**CITY OF ALBUQUERQUE
PLANNING DEPARTMENT
February 27, 2008
DRB Comments**

ITEM # 13

PROJECT # 1003554 APPLICATION # 08-70081

RE: Lot 5-A, Central Park Place

LOT 5-A-1 AND 5-A-2 CENTRAL PARK PLACE

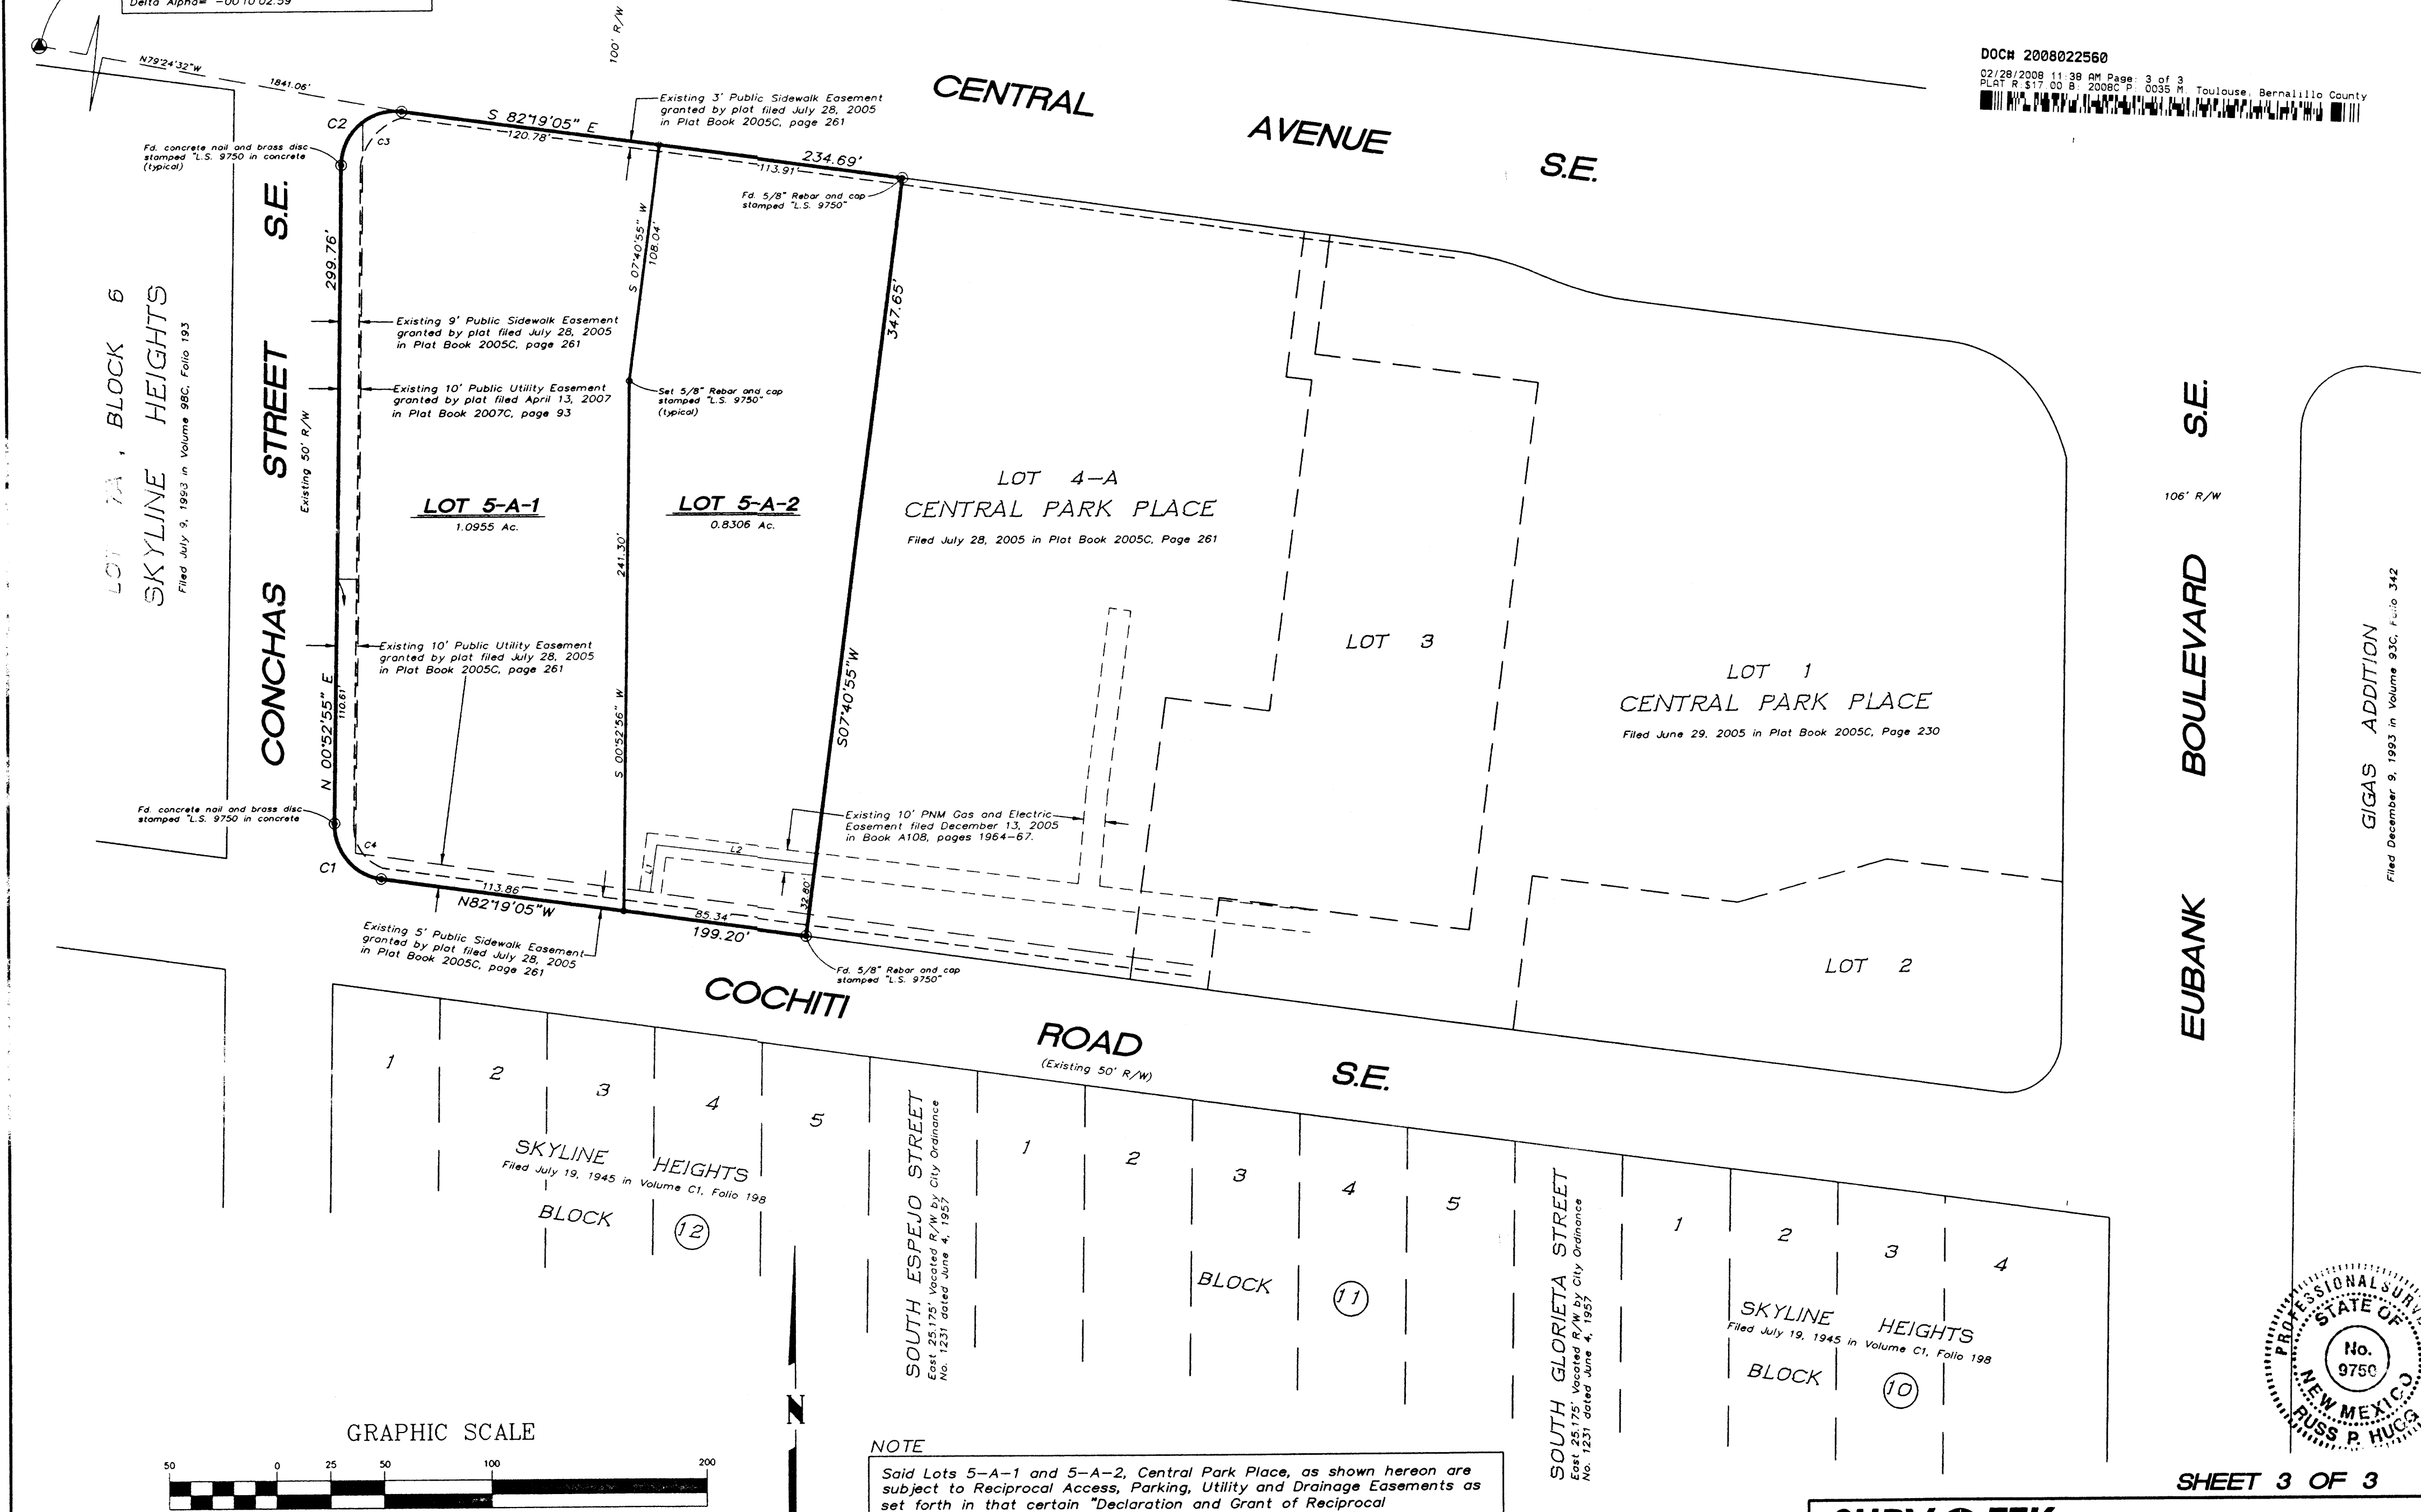
Delete Note 8 RE: current zoning.

Revise Note on page 3 to reflect proposed lot numbers.

For future reference, please revise solar note (No. 4) to be specific to this type of request, i.e. replace the words "REQUESTED FINAL ACTION" with the words "THIS PLAT" and delete the words "OR SITE DEVELOPMENT PLAN FOR SUBDIVISION" at the end of the note.
